Epping to Thornleigh Third Track Proposal. Application number SSI 5132.

I/we object to the Epping to Thornleigh Third Track Proposal and consider that the EIS is inadequate and does not address the full impact of this proposal. It will cause untold damage to the health of residents and to the fabric of the Beecroft Cheltenham Heritage Conservation Area. Do not approve this project, reconsider the alternatives and protect the community.

Figure 5.6 Cross-section and elevation - New Cheltenham Station concourse building
Note: Indicatively added to future design

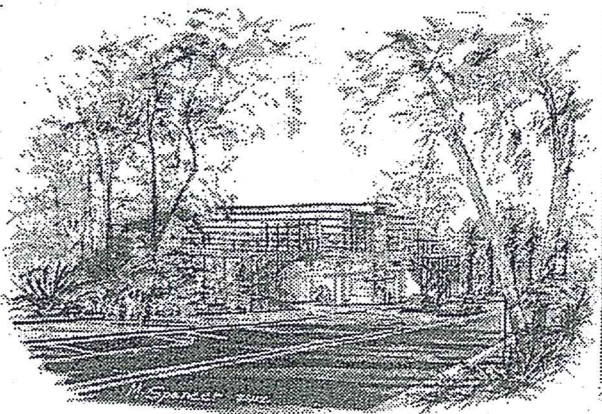
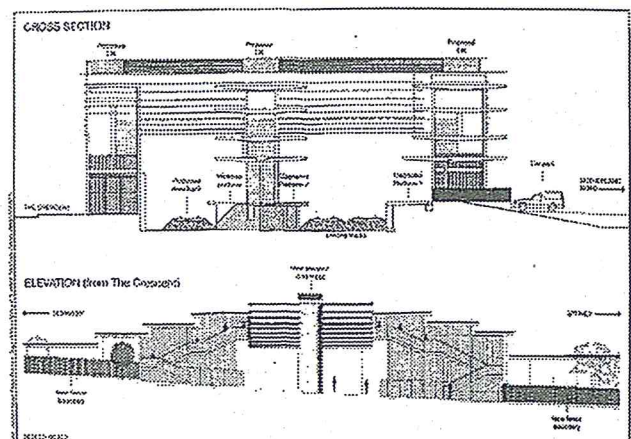
- The proposed redevelopment of Cheltenham Station shows no regard for the HCA. The visual impact of the proposed 13m high glass and steel concourse is totally unacceptable in this HCA.
